From: Amanda Scholes on behalf of Planning.Responses
Sent: 26 June 2017 08:41
To: Planning Scanning
Subject: FW: Planning Consultation on: A/99/17/OUT

Environmental Health:

APPLICATION **A/99/17/OUT**

Site Address: Land South of Water Lane Angmering

Figure 6: Noise Barrier Locations & Daytime Contours

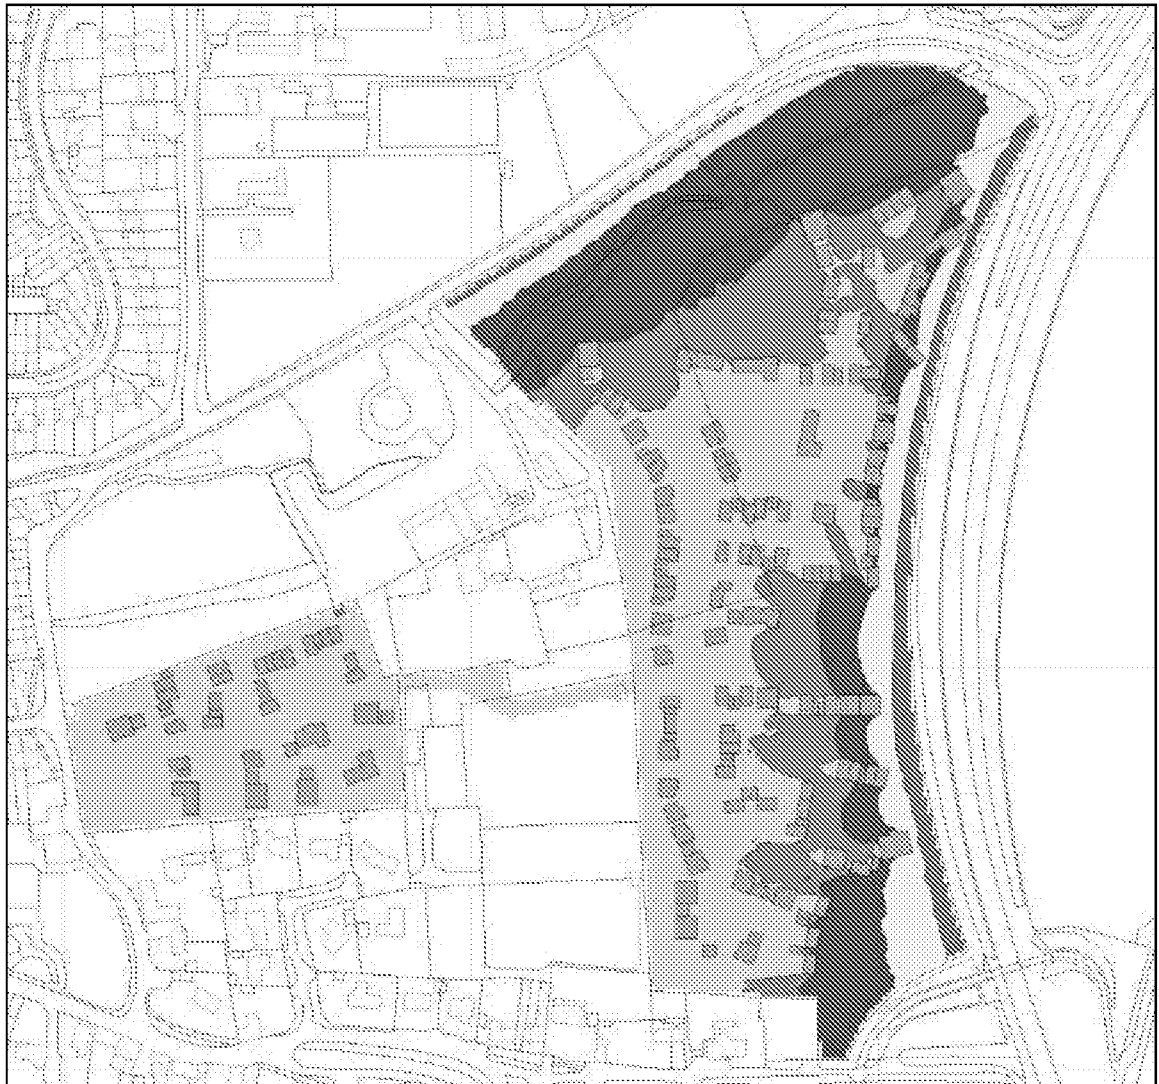
Noise to external Amenity Areas: The WHO indicates that to protect the majority of people from being seriously annoyed during the daytime, the sound pressure level in gardens should not exceed 55dB LAeq. To protect the majority of people from being moderately annoyed during the daytime, then the outdoor sound pressure level should not exceed 50 dB LAeq. This is the preferred level. 2m high acoustic barriers have been proposed (paragraph 5.15 and 5.16) to external amenity areas which would otherwise be subject to unacceptably high noise levels. This should be built as either :-

- * abutting panels not less than 22mm thick, with joints sealed by cover strips not less than 22mm thick and strip endings not less than 25% over adjacent panels. Or

- * Not less than 100mm thick brick or rendered blockwork.
